**Re: SSD-8996 - Loreto Normanhurst - 91-93 Pennant Hills Road and 6-12 Mount Pleasant Avenue, Normanhurst.**

I refer to the above development proposal and provide the following comments from Council.

Drawing Title
SITE ELEVATIONS

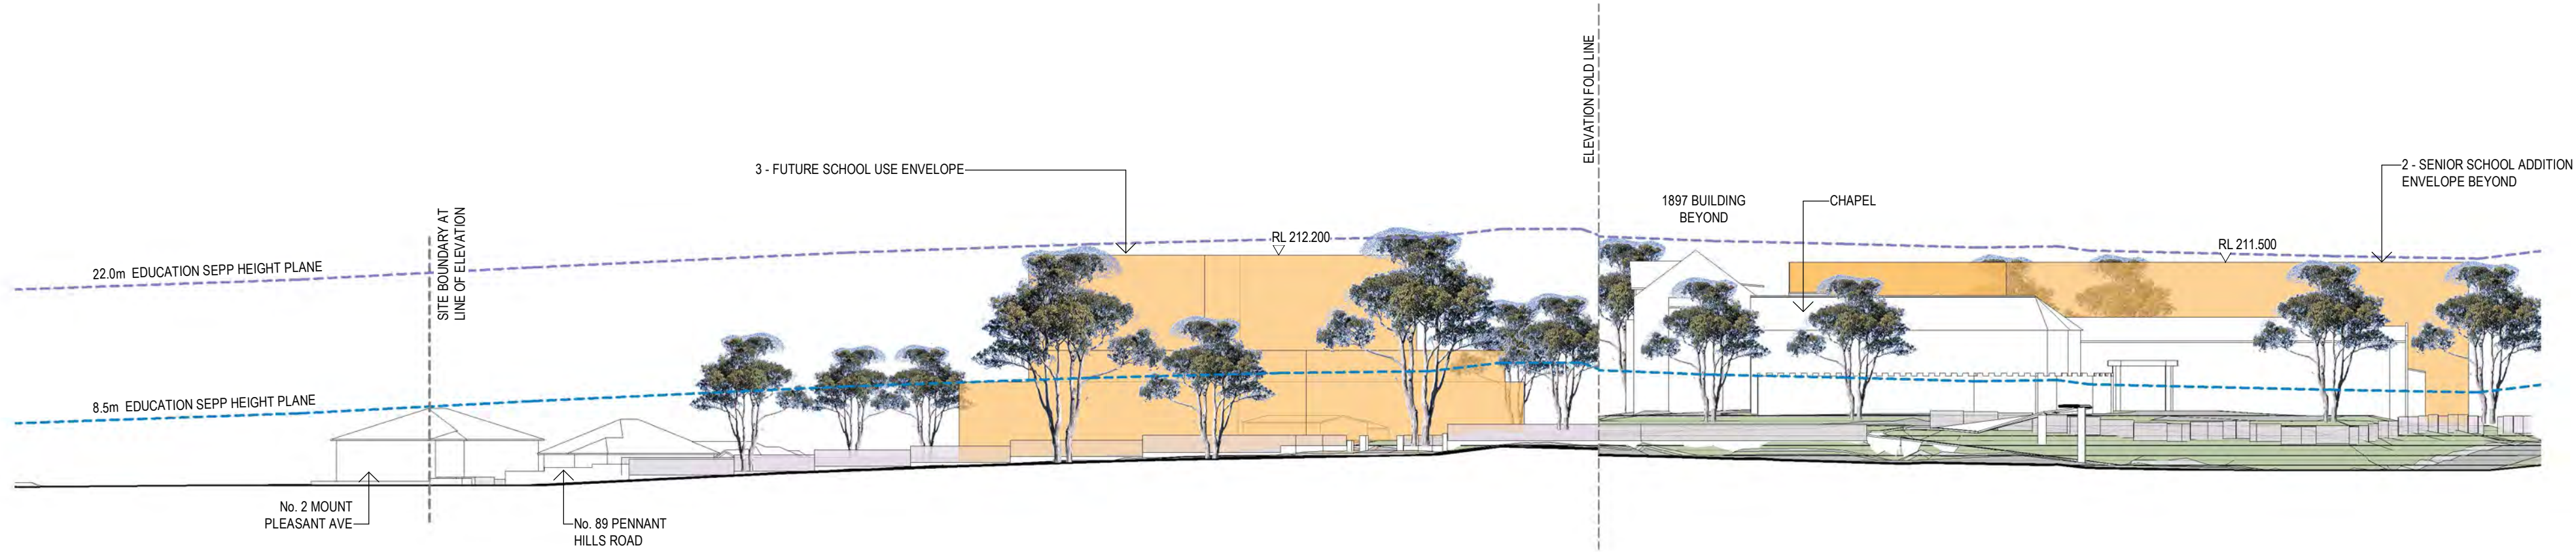
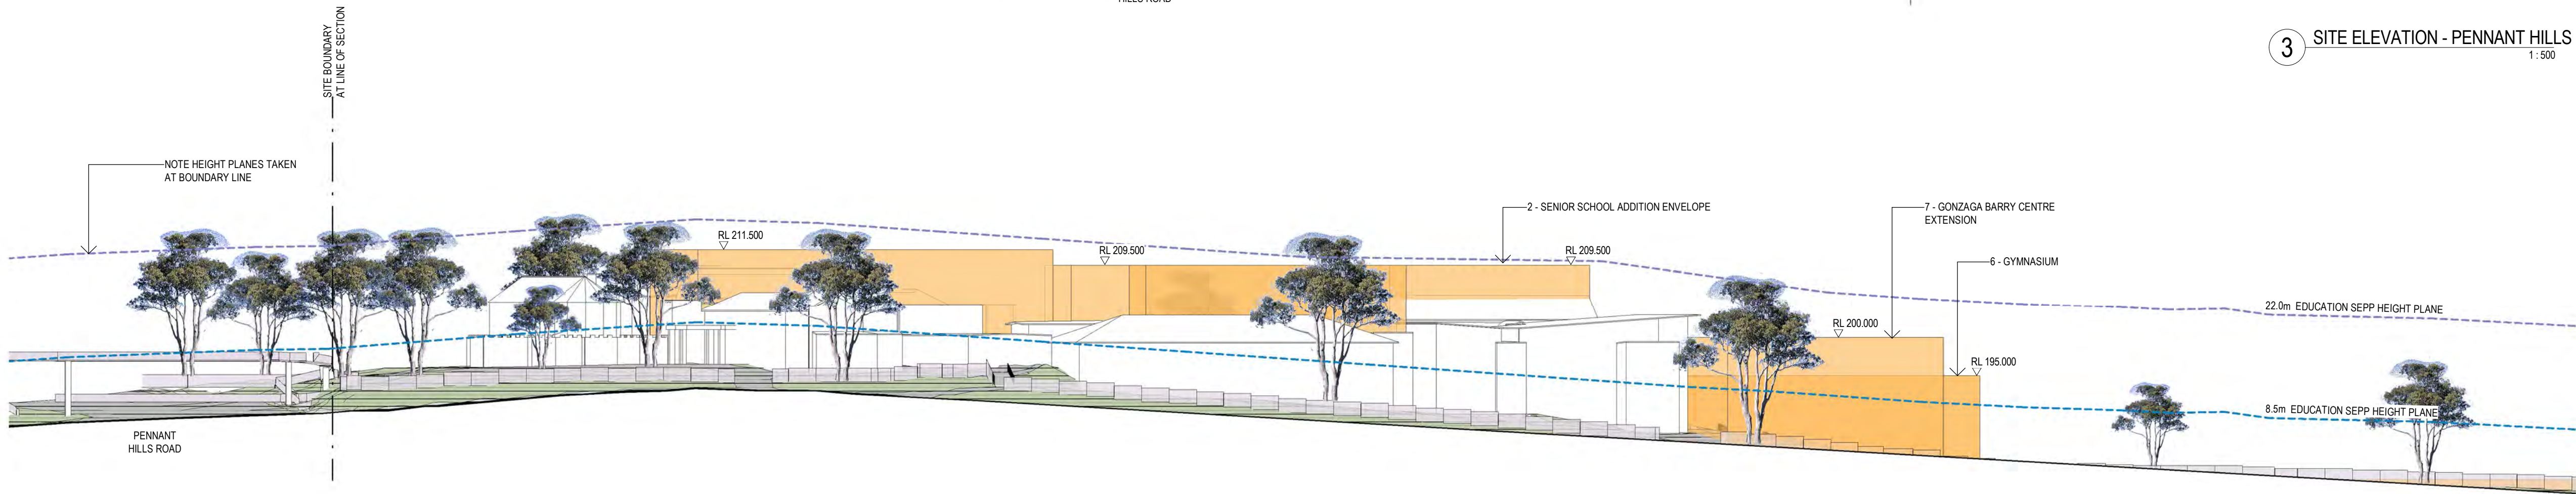
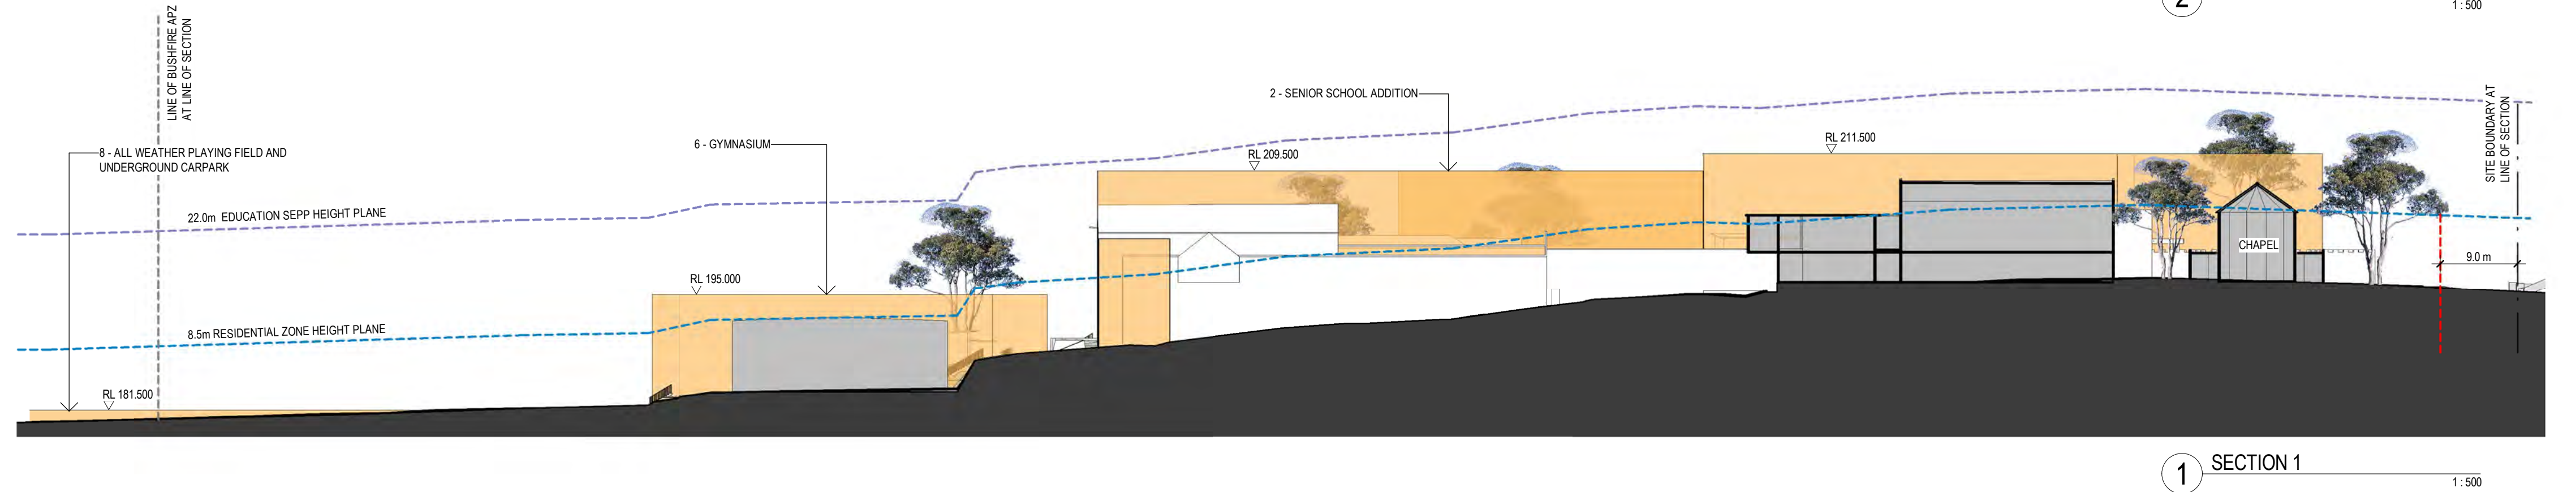
The proposed boarding house building would result in excessive height, bulk and scale when viewed from adjacent properties in Mount Pleasant Avenue.

The scale of future development in the Master concept plan (Envelope 3) has the potential to adversely alter the residential low scaled setting of the heritage item in the vicinity at No. 4 Mount Pleasant Avenue, Normanhurst.

Drawing Title
**OVERALL 3D VIEW -
FUTURE PROJECTS**
Sheet Status
NOT FOR CONSTRUCTION

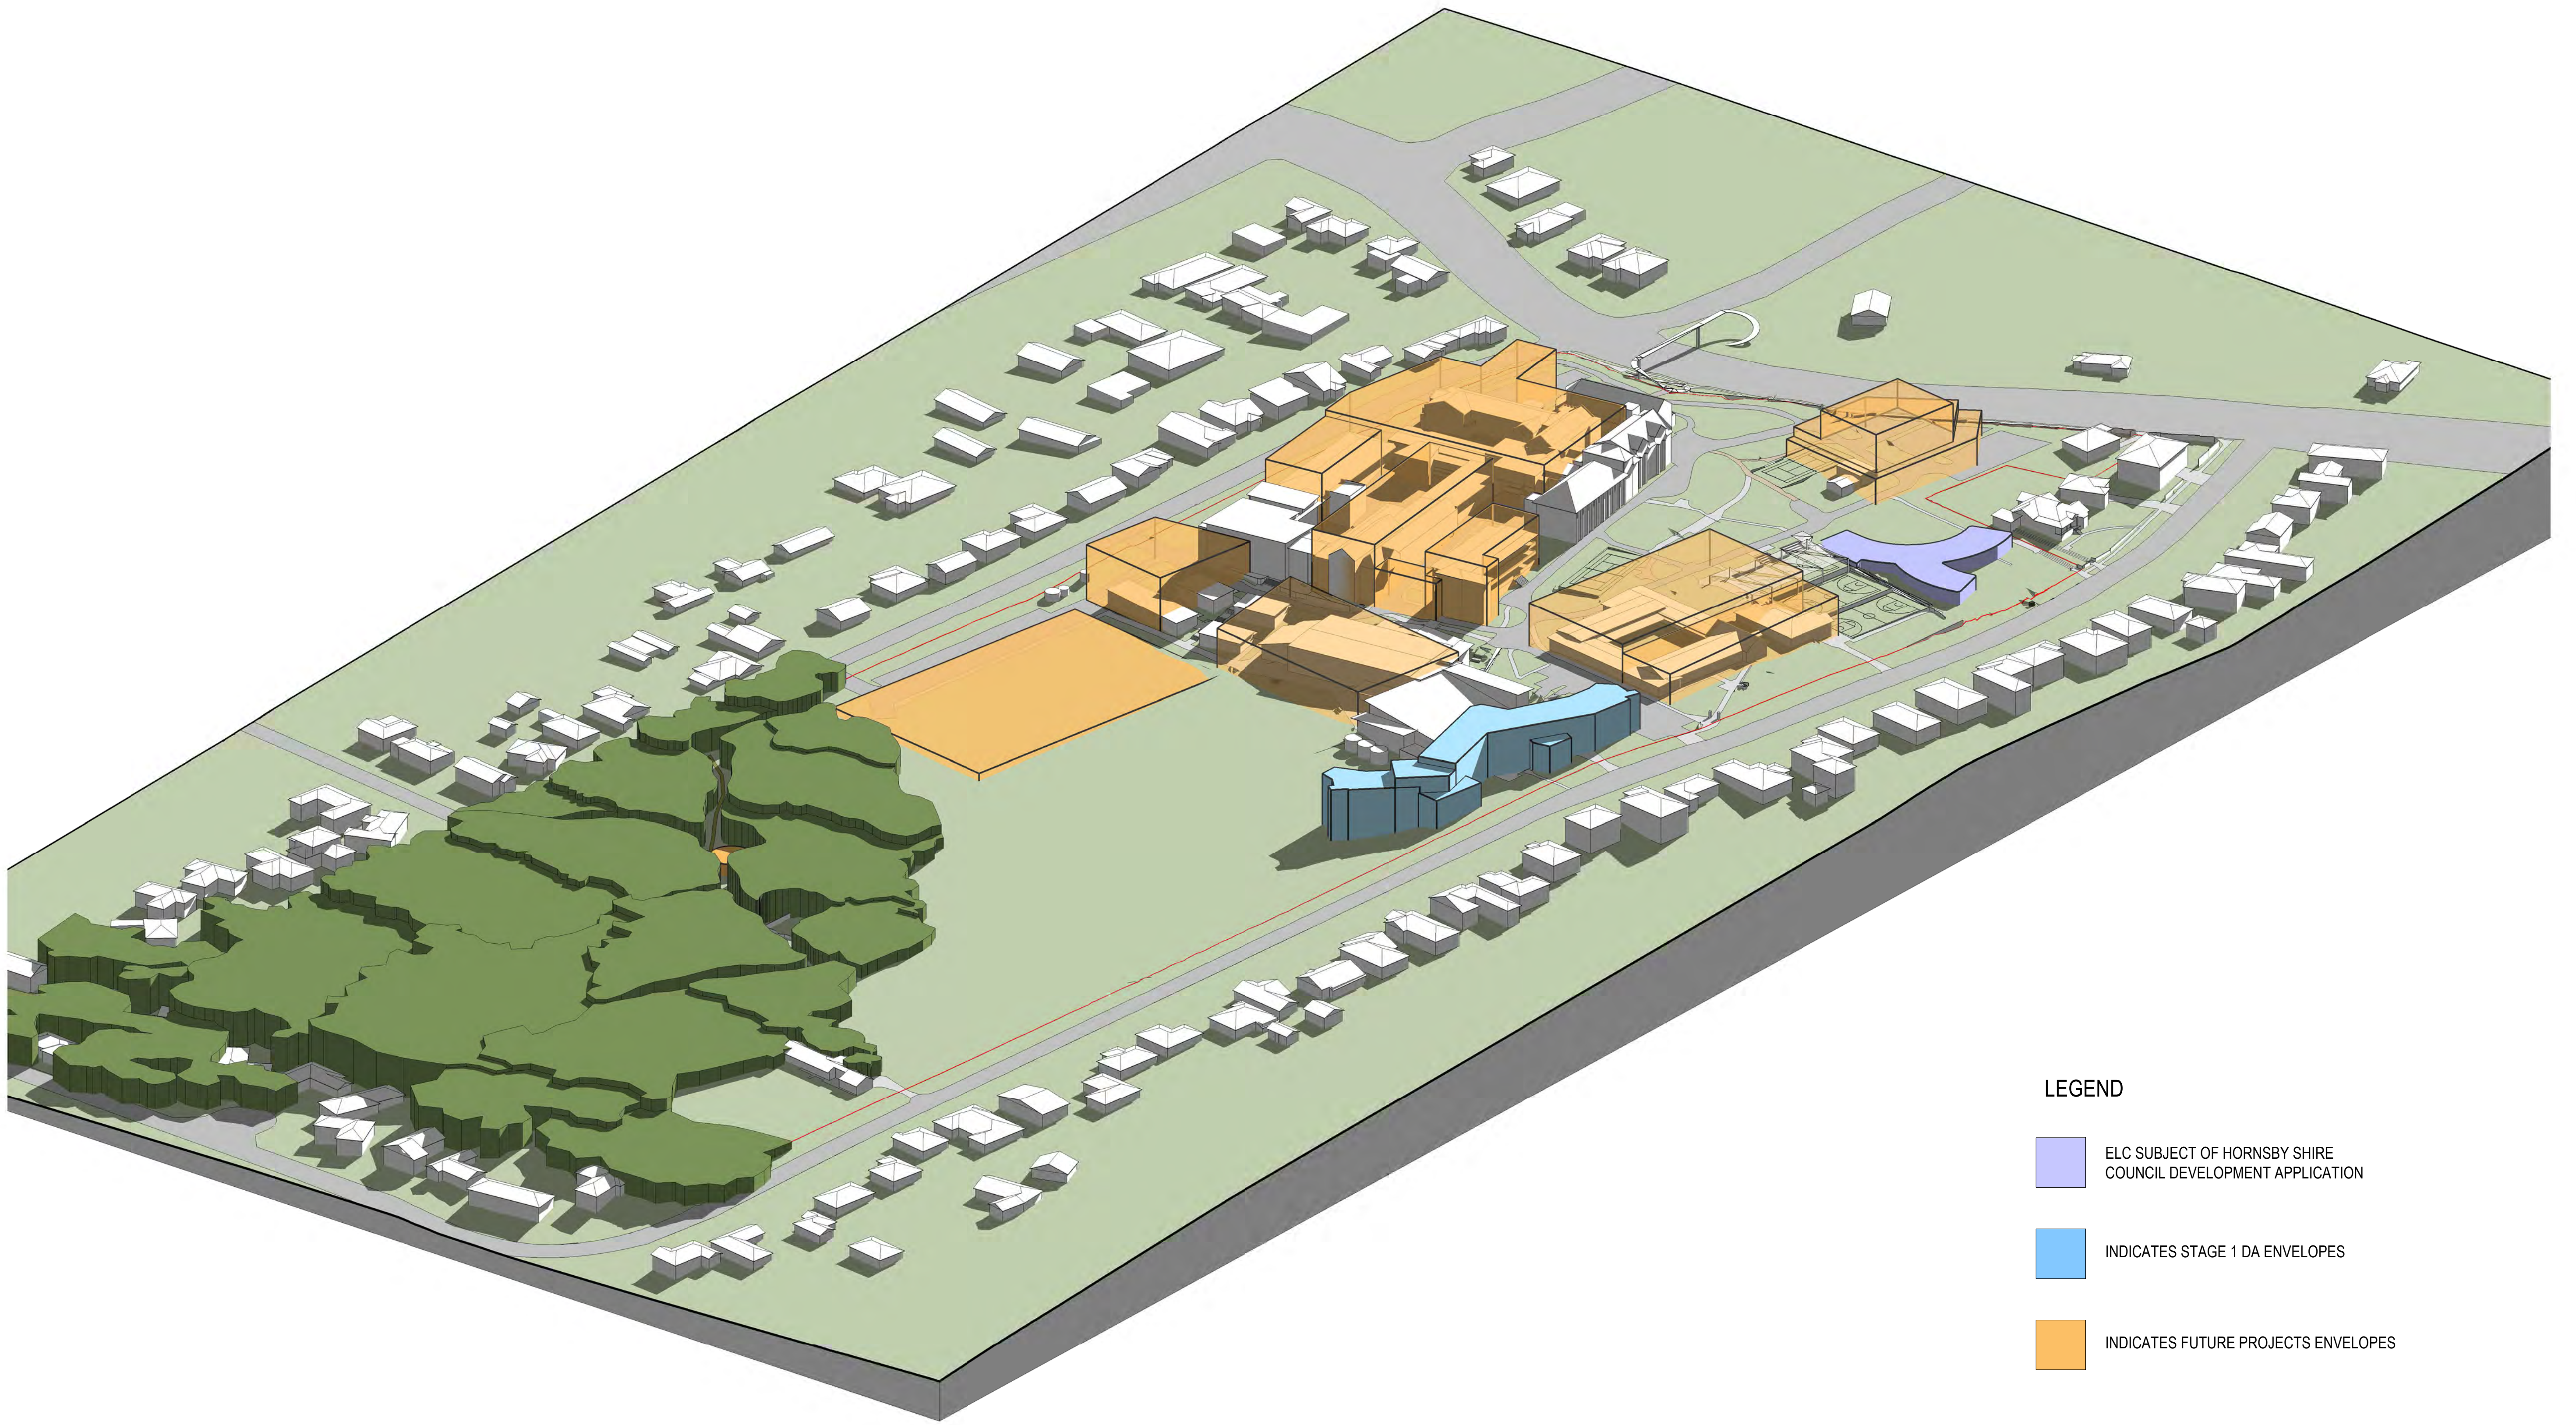
Envelope 3 – Future development (adjacent Pennant Hills Road; north east of the convent and chapel) to be determined; underground carpark	<p>The proposed concept development is of a height and scale that would be out of character with the scale of the heritage items on the site. The structure would adversely impact the landscaped setting of the convent and chapel on the northern and eastern sections of the site. The listed grounds would also be adversely impacted, as well as the original setting of the listed entry and gates. Development in this section should remain largely landscaped as a link to the original setting and understanding of the site. This development could also irreversibly remove potential for historic views of the convent to be revealed. In addition, views internally from the Covent and chapel area out of the site would be adversely impacted, by the proposed building.</p> <p>It is suggested that proposed future buildings for this area be located elsewhere. For example, in Mount Pleasant Avenue adjacent the new ELC, and the current sports courts in Mount Pleasant Avenue relocated to Envelope 3 and landscaped. Alternatively, locate new buildings to Envelope 9, 7 or 6.</p> <p><b>The redevelopment proposed would have an adverse impact and is not supported in heritage terms.</b></p>
